Consultation Response from KC, Lead Local Flood Authority		
2021/90800 Hinchliffe Mill, Water Street, Holmbridge, Holmfirth, HD9 2NX		
Redevelopment and change of use of former mill site to form seven residential units within the mill building and erection of 17 dwellings (within a Conservation Area)		
Date Responded: 29 March 2021	Responding Officer: Aleksandra Tomczyk	Responding Ref: 0

Kirklees Flood Management and Drainage, as the Lead local Flood Authority (LLFA), OBJECT to this planning application and require FURTHER INFORMATION is provided on the following:

- Flood risk assessment;
- Surface water drainage design.

Project		Hinchliffe Mill	
Title		Proposed Drainage Layout (2 of 2)	
Org Scale	1:200 @ A1	Drawn	AD
Checked	chk'd	CHG job No.	G560
Drawing Number		Revision	
G560-CHG-XX-00-DR-C-0301		P3

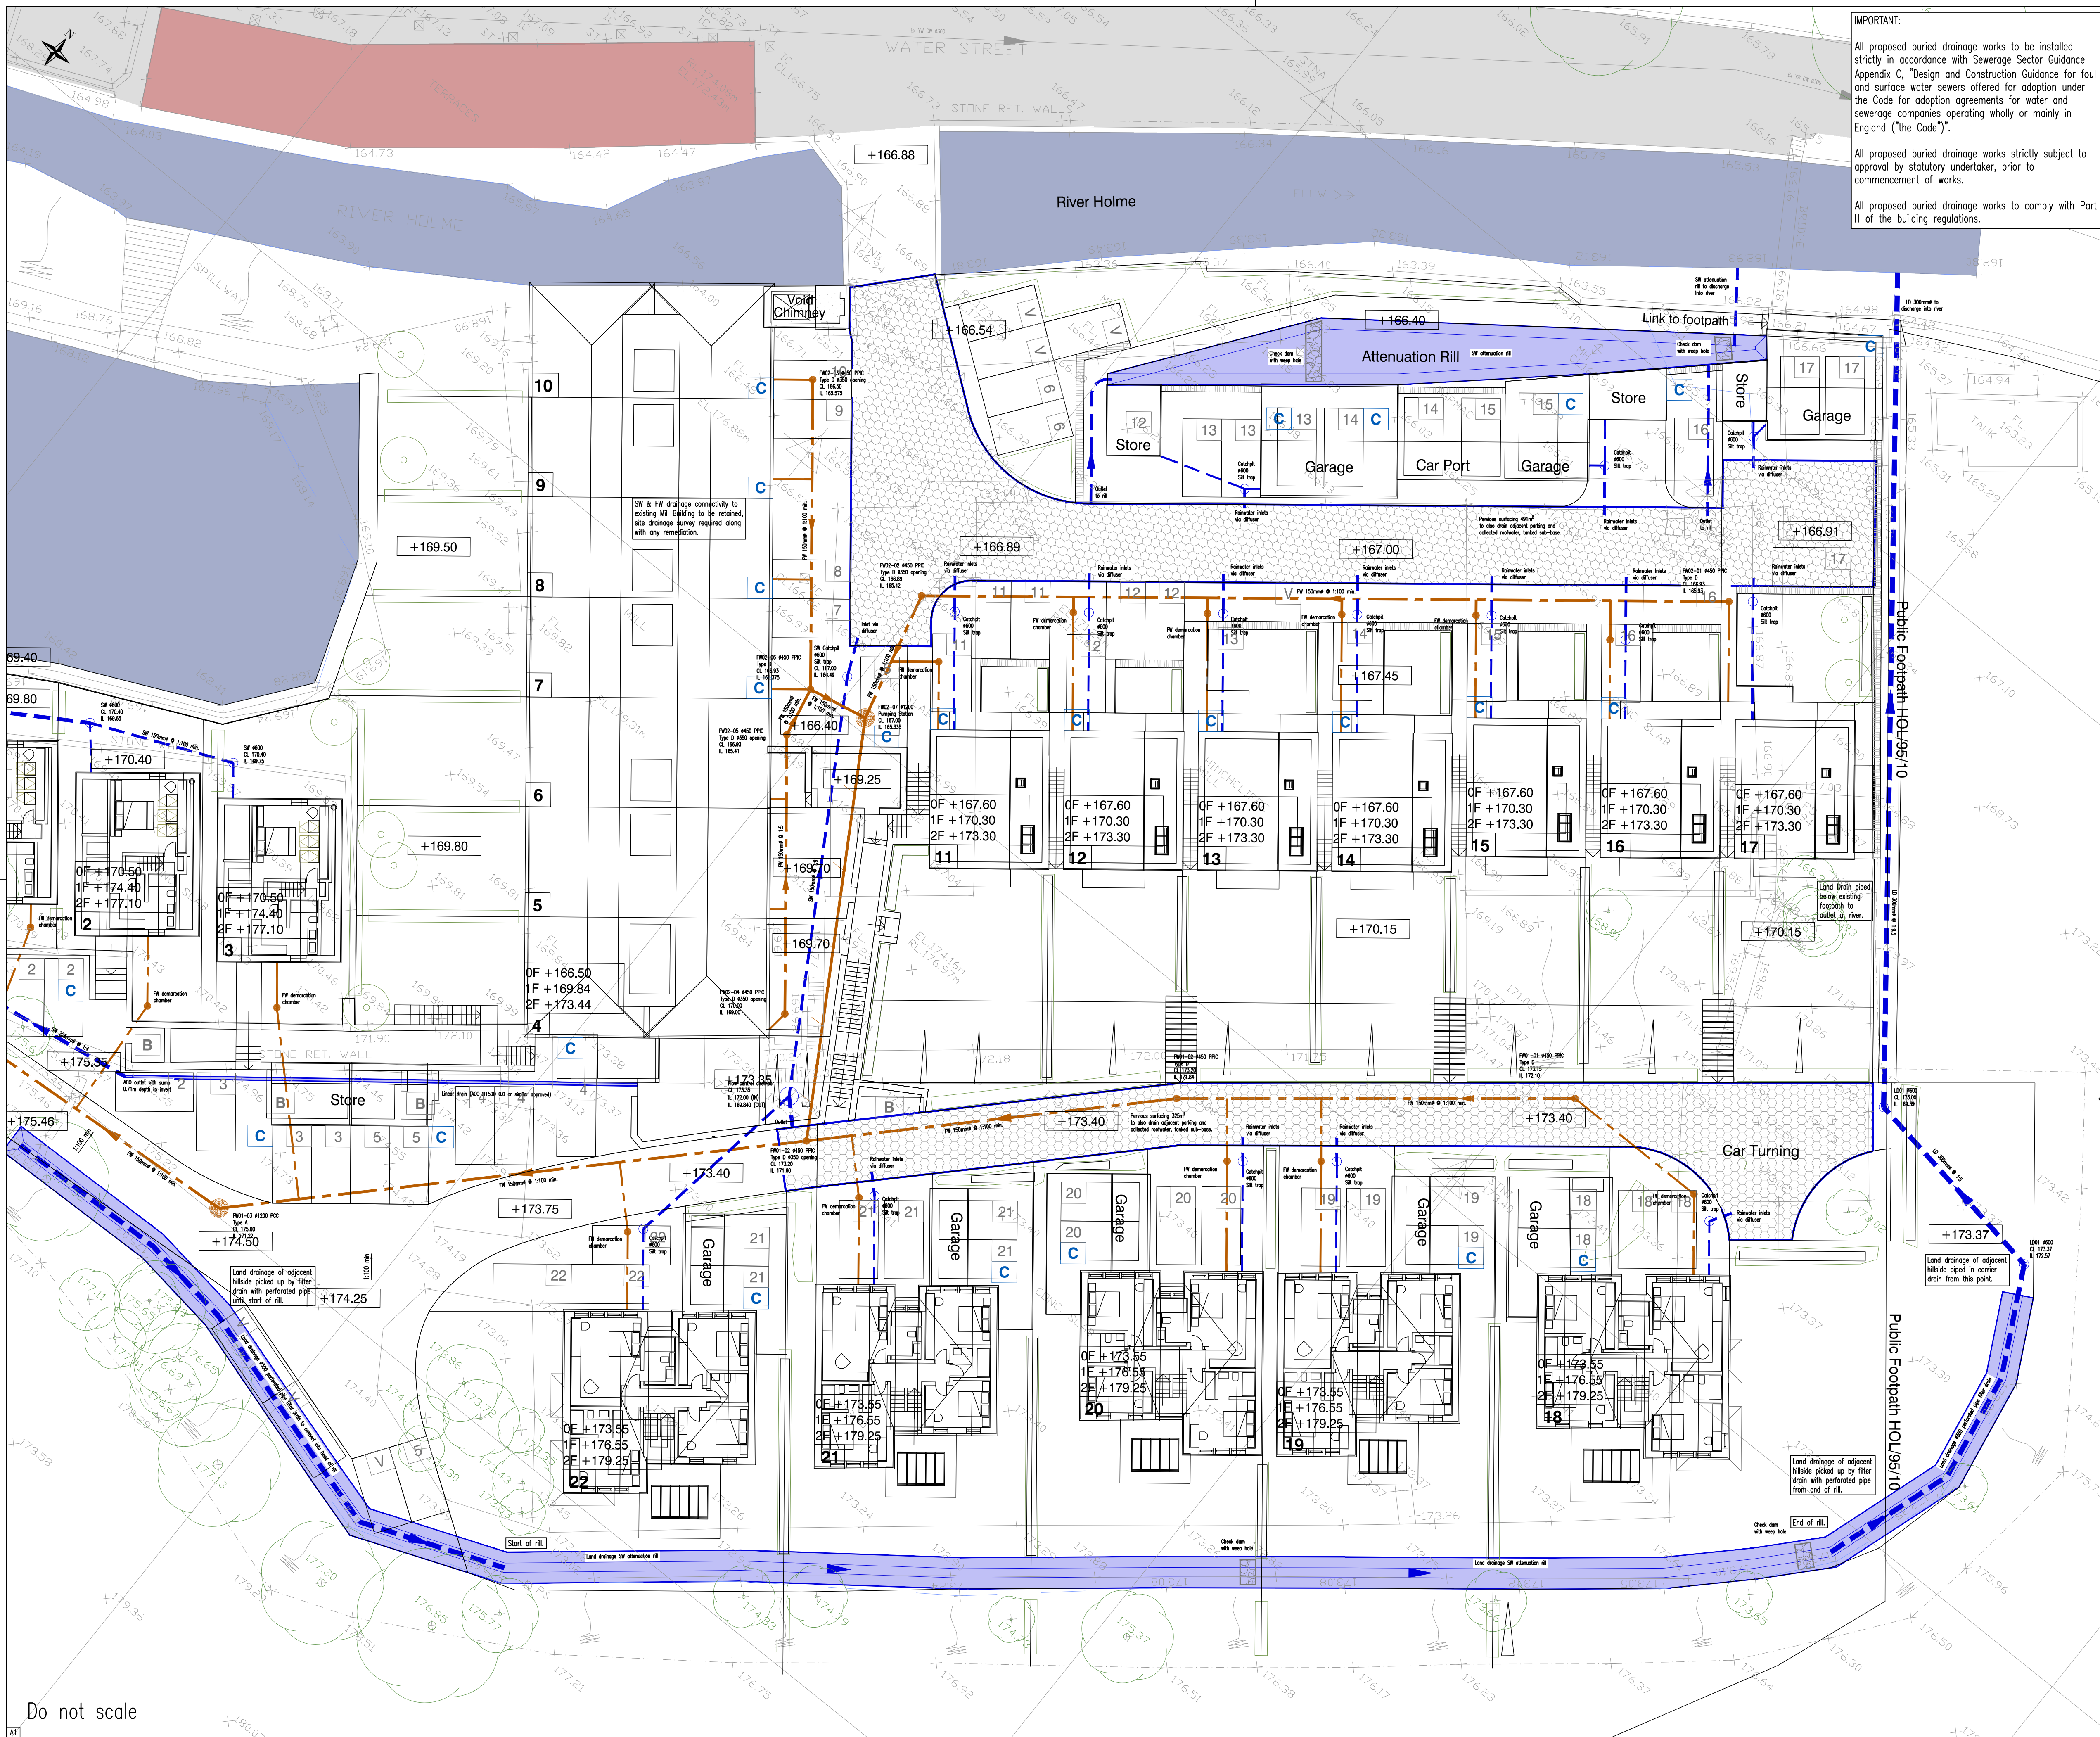
- *Design and Access Statement*, prepared by One 17 Design, dated January 2021;
- *Flood Risk Assessment*, prepared by Collins Hall Green, reference G560-CHG-00-XX-RP-S-0003, revision A, dated February 2021;
- *Drainage Strategy*, prepared by Collins Hall Green, version 1.1, dated January 2021;
- *Drawing OS Location Plan*, prepared by One 17 Design, number 3372 (OS) 01, dated February 2021;
- *Drawing Overall Site Plan and Elevation*, prepared by One 17 Design, number 3372 (0-) 623, dated January 2021;
- *Drawing Proposed Drainage Layout (1 of 2)*, prepared by Collins Hall Green, number G560-CHG-XX-00-DR-C-0300, revision P2, dated 10.02.21; and
- *Drawing Proposed Drainage Layout (2 of 2)*, prepared by Collins Hall Green, number G560-CHG-XX-00-DR-C-0301, revision P3, dated 11.02.21.

- Based on the Environment Agency *Flood map for planning* and the provided *OS Location Plan*, this proposed development is partially located within Flood Zones 2 and 3 – this is not stated in the report and should be amended accordingly.
- The document should clearly state what the design flood level is for this development.
- Section 5.6 shows the proposed finished floor levels – the LLFA have **no objection in principle** to the proposed levels. This aspect should be covered by a suitable condition once approval is given.
- Section 5.7 states the proposed safe access and egress route. The LLFA have **no objection in principle** to this proposal. This aspect should be covered by a suitable condition once approval is given. Any plans should indicate that public should not cross the Dobb Lane bridge over River Holme, and should follow Dobb Lane further south.

- Section 3 states that infrastructure information would be obtained from United Utilities. The LLFA highlight that the organisation responsible for drainage in Kirklees area is Yorkshire Water.
- Section 3.7 states the peak flow estimates before and after the 30% reduction – 142.4l/s and 87.2l/s respectively. The applicant should confirm whether the area of the mill pond has been included in the calculations.
- The LLFA have **no objection in principle** to the proposed discharge points.
- The applicant should provide details of how the proposed pervious surfacing will be managed and maintained to retain its porosity and storage capability.
